DARLINGTON PUBLIC SCHOOL
 SSD - 9914 ARCHITECTURAL DESIGN UPDATE

RESPONSE TO GANSW

GOLDEN GROVE STREET, DARLINGTON, SYDNEY
 Department of Education

fjmt studio architecture interiors urban landscape
 28 SEPTEMBER 2020 REV 01

title
**Perspective Sections - Facade
Western Facade - FT01, 07, 09, 10**

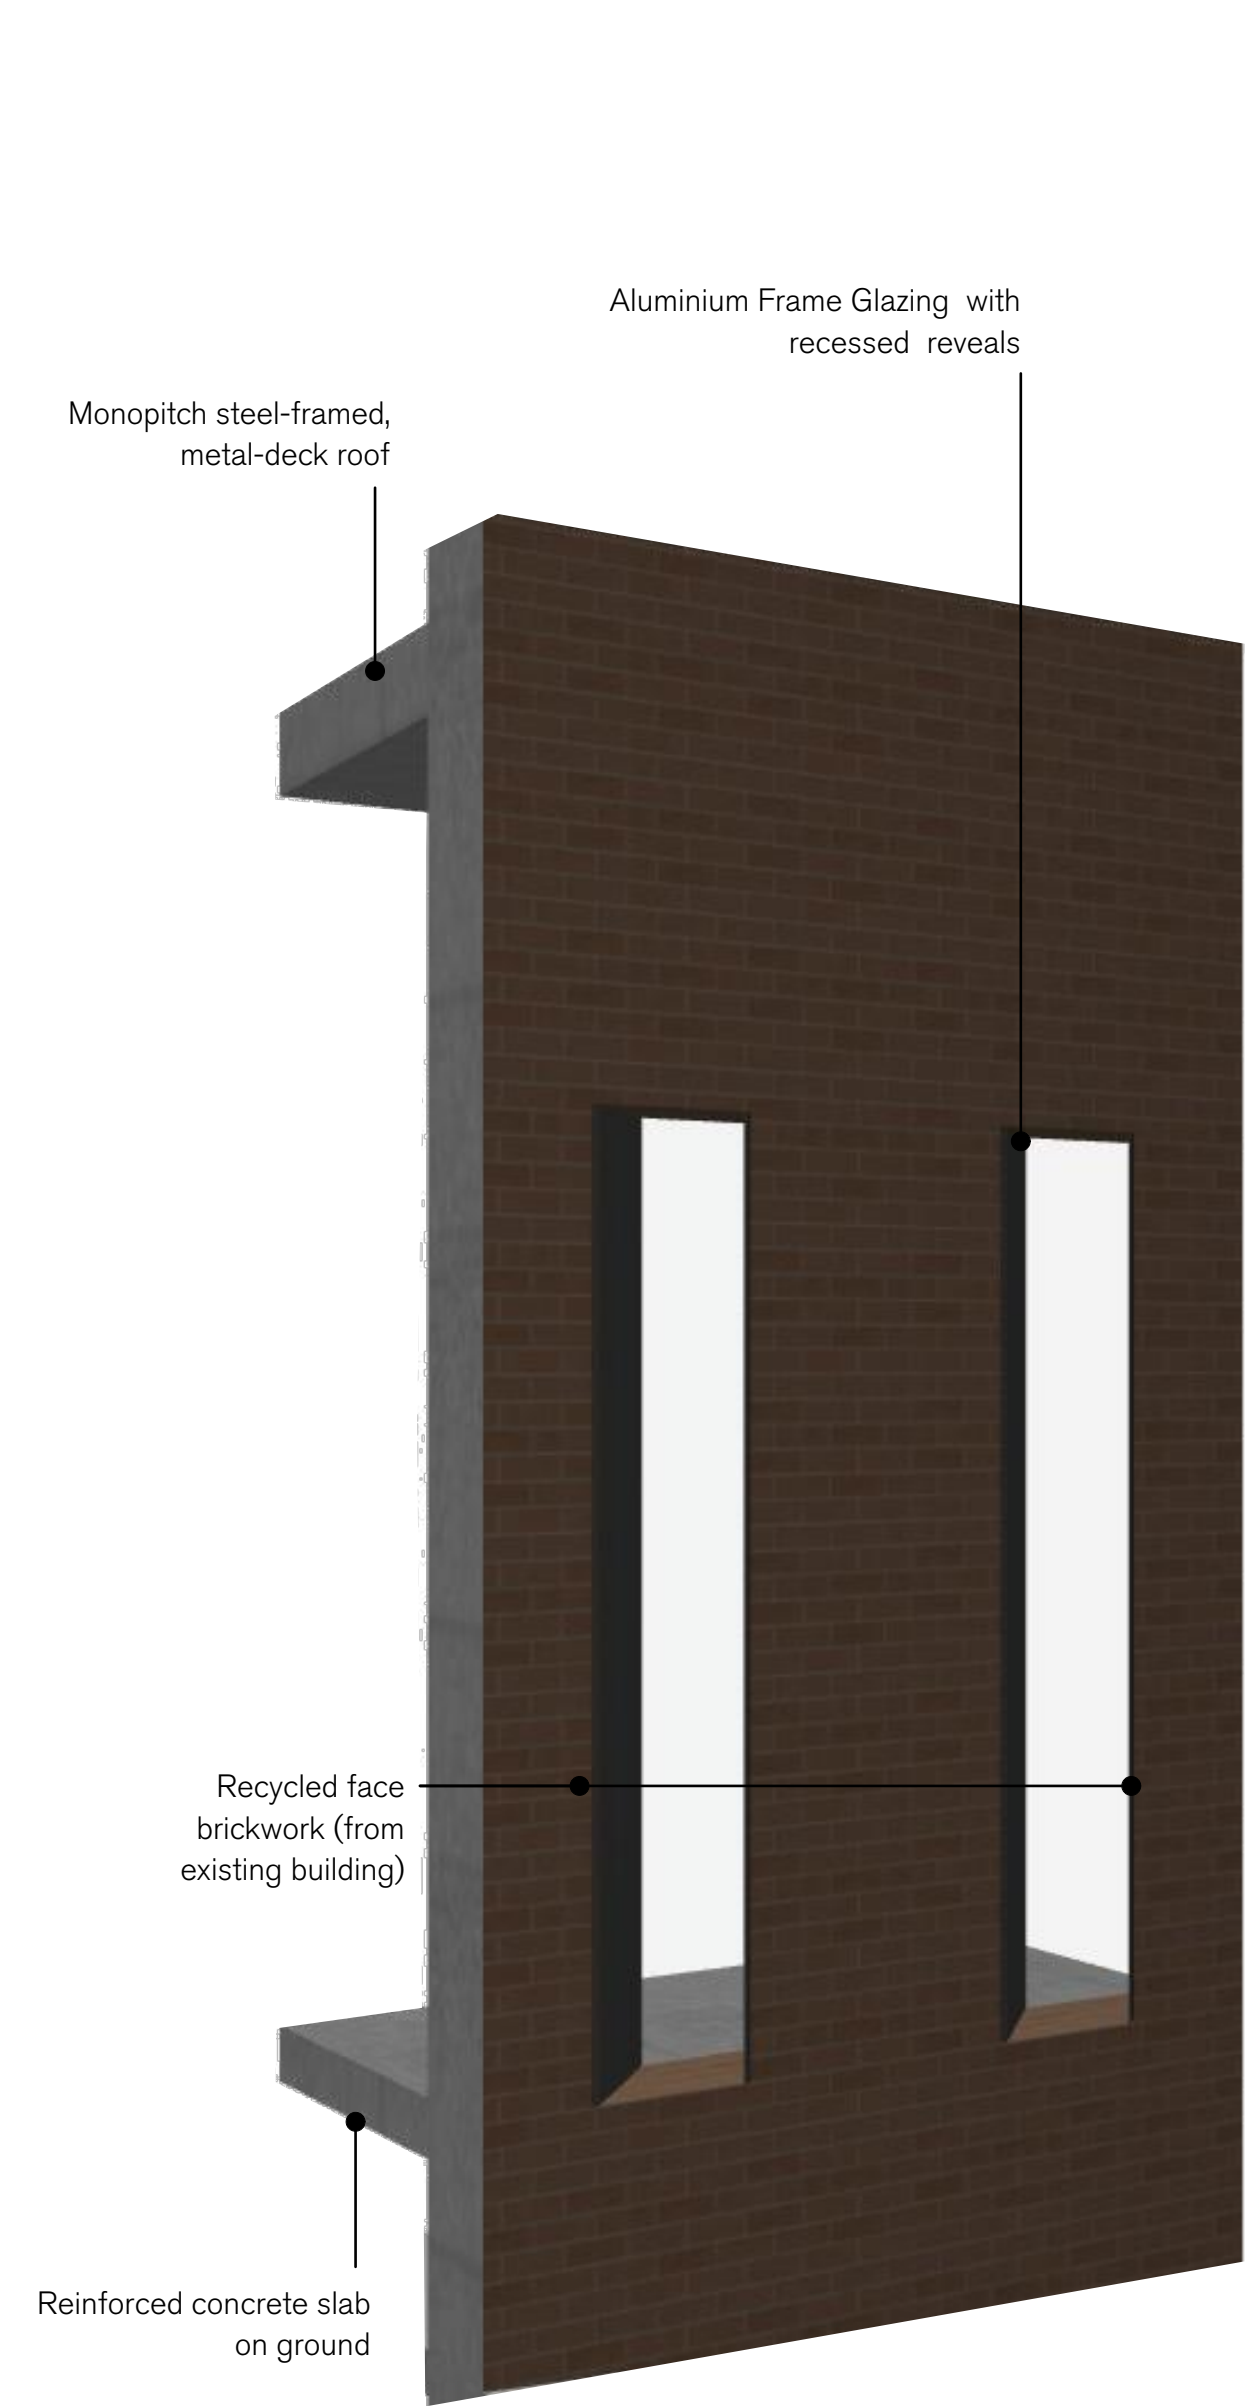
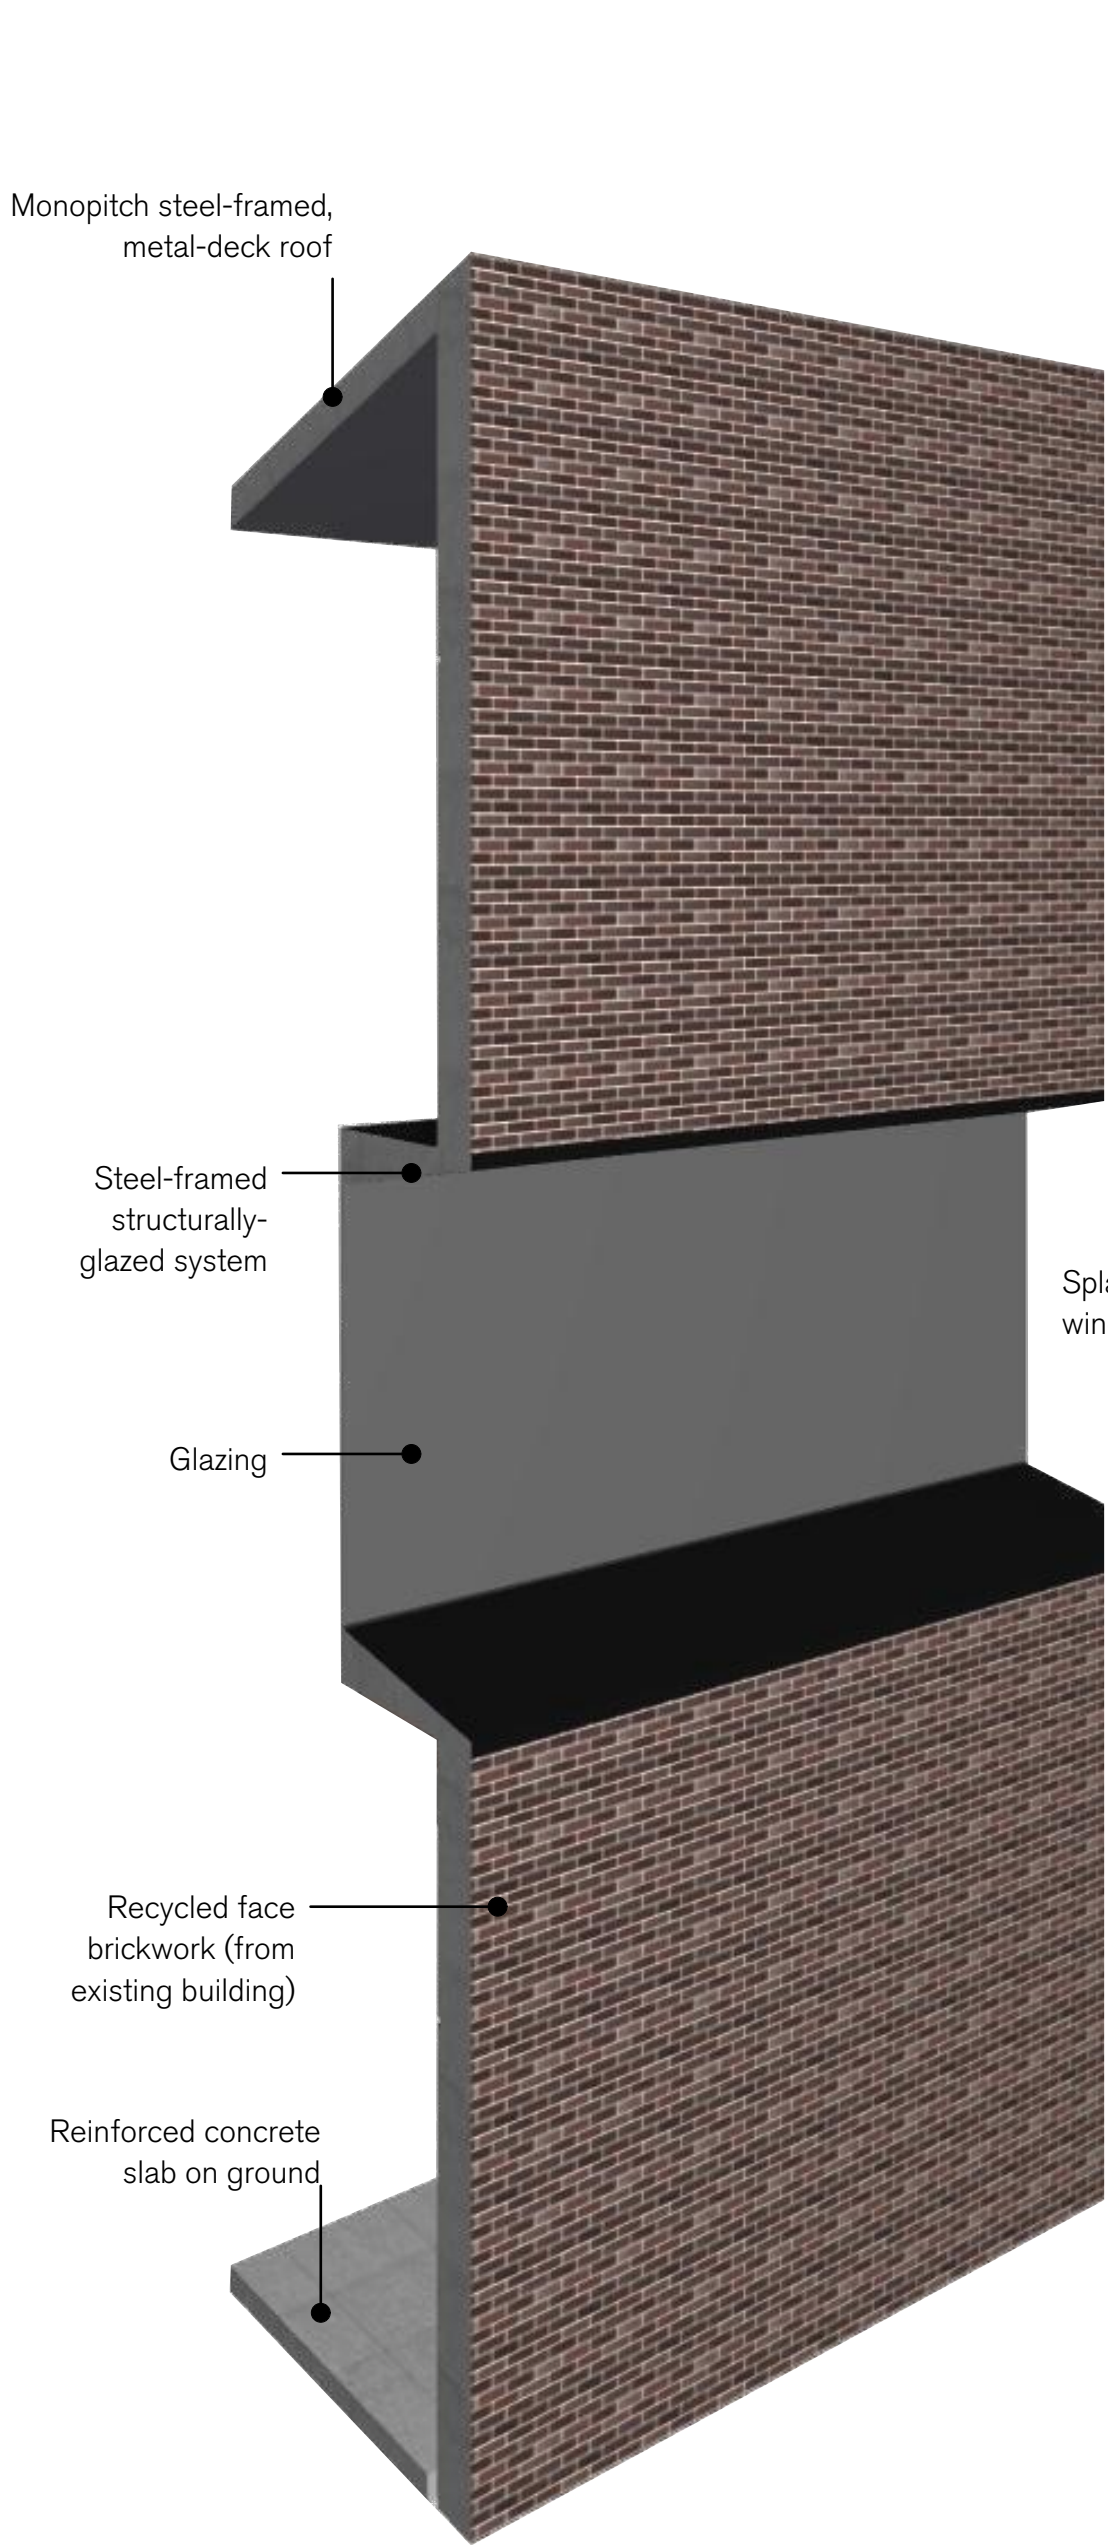
Item	Government Architect Initial Response to SSDA, 09 July 2020	fjmt Response	Page
1	The proposed buildings present large blank facades to both Golden Grove and Abercrombie streets. Articulation of the facades, further definition of openings and detailing of materials to positively address the public domain is requested.	<p>The facades facing Abercrombie Street have been further developed and articulation to the western and southern facades has been incorporated.</p> <p>The glazing and brickwork to the southern facade of the hall building has been detailed to provide a finer grain response to the streetscape.</p> <p>The previous single large window into the south facade of the communal hall has been divided into 5 smaller windows. These are set into a recessed brick facade with large splayed sills and clearly defined brick blades between the glazing elements.</p> <p>This creates a more interesting street frontage, responding to the local context and a more structurally efficient result.</p> <p>The openings along the low-level brick facade facing Golden Grove street have also been refined.</p>	Refer Section 1.0, pages 5-10.
